## **Addendum to Design and Access statement incorporating a brief Heritage Statement and response to recent letter from The Gardens Trust.**

Following a response letter received from The Gardens Trust to the application 23/01646/F for Heyford Lodge we set out below our response and brief "Heritage Statement".

Rev	
Project Heyford Lodge Park Farm Middleton Stoney	
Client J H Norman & Sons	
Drawing Proposed All Elevations	
Drawing No: 02/2023/05	
Issued for: Planning	
Date Mch 2023	Drawn by MCH
Scale(s) at A3size 1:100@A3

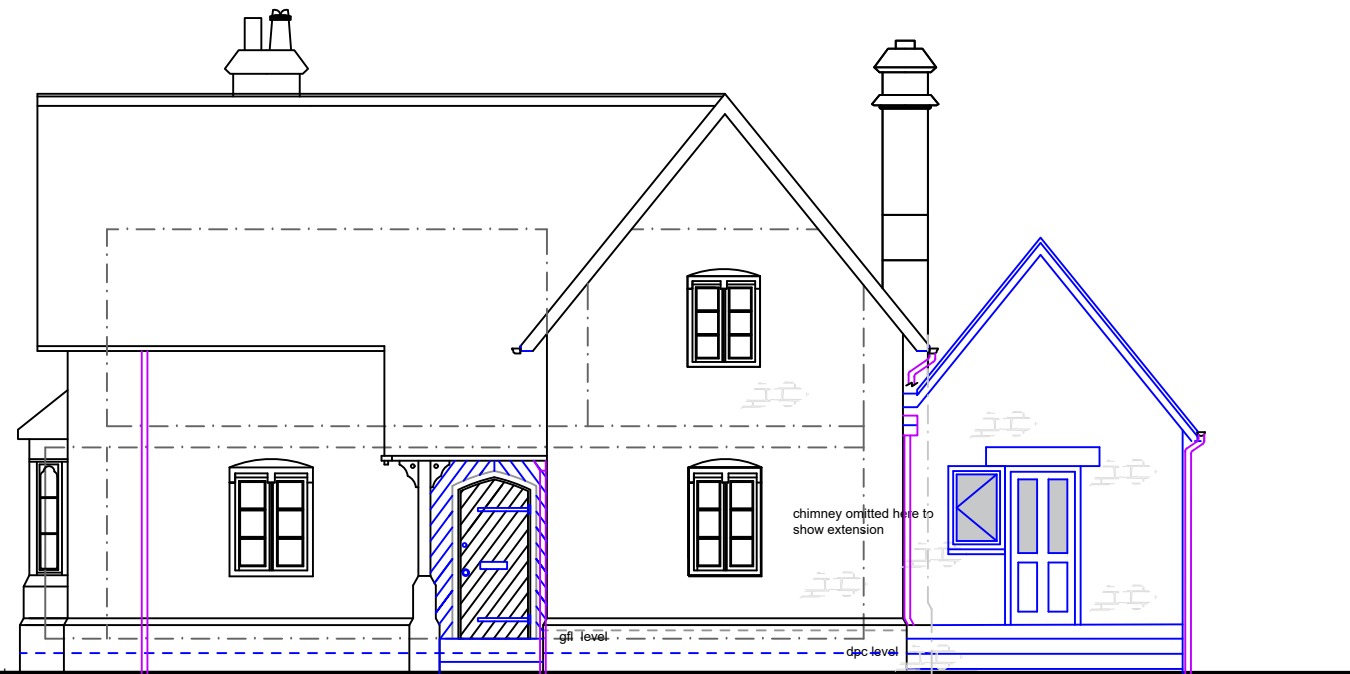
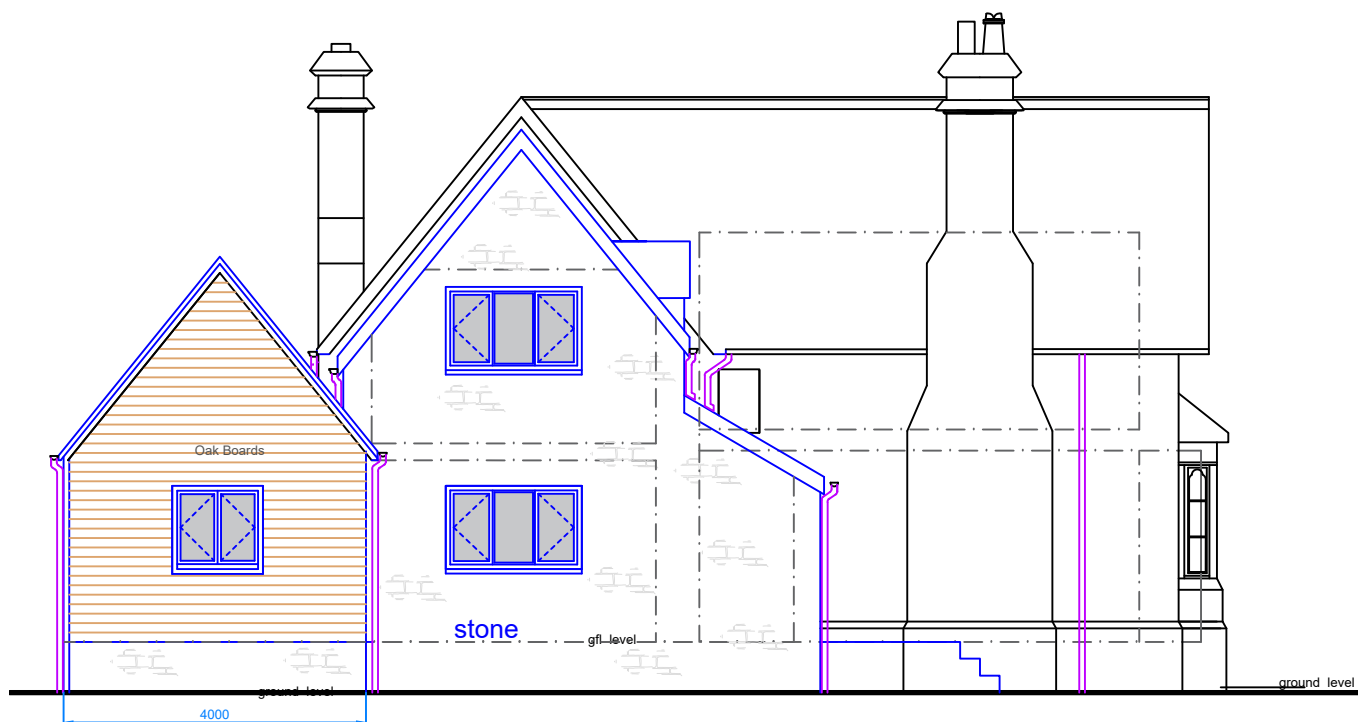
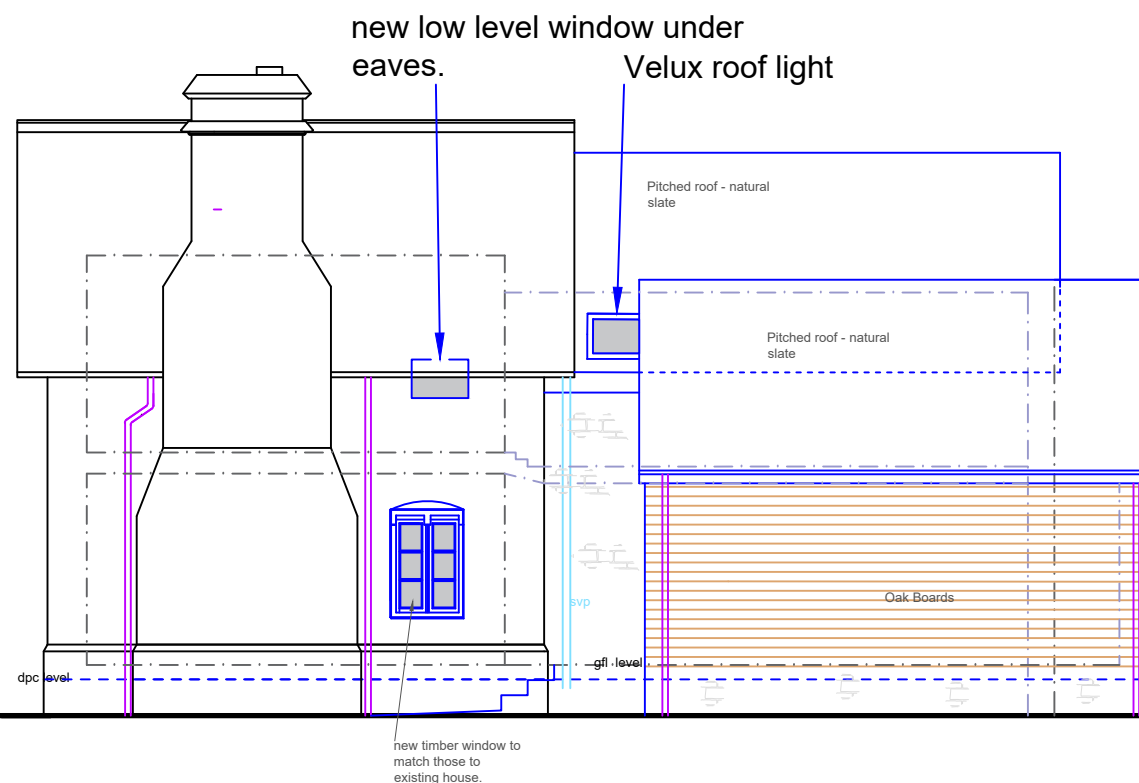
Comments on the design have been made by The Gardens Trust. We can see no issues with the juxtaposition of the single storey rear side extension to the main extension or house. It has been designed to be in more rustic local materials on an elevation only visible from the main road and not from the RPG. This reflects the reduced status of the rear and side elevations of the existing Lodge.

The front east facing principal elevation of the lodge is not affected by the proposals and the single storey extension that faces east is set well back and itself faced with natural stonework to compliment the main lodge façade. It will be hard to see from the driveway and has no material effect on the RPG. Opinions on design will always differ and we see no reason to make any alterations to the current proposals.
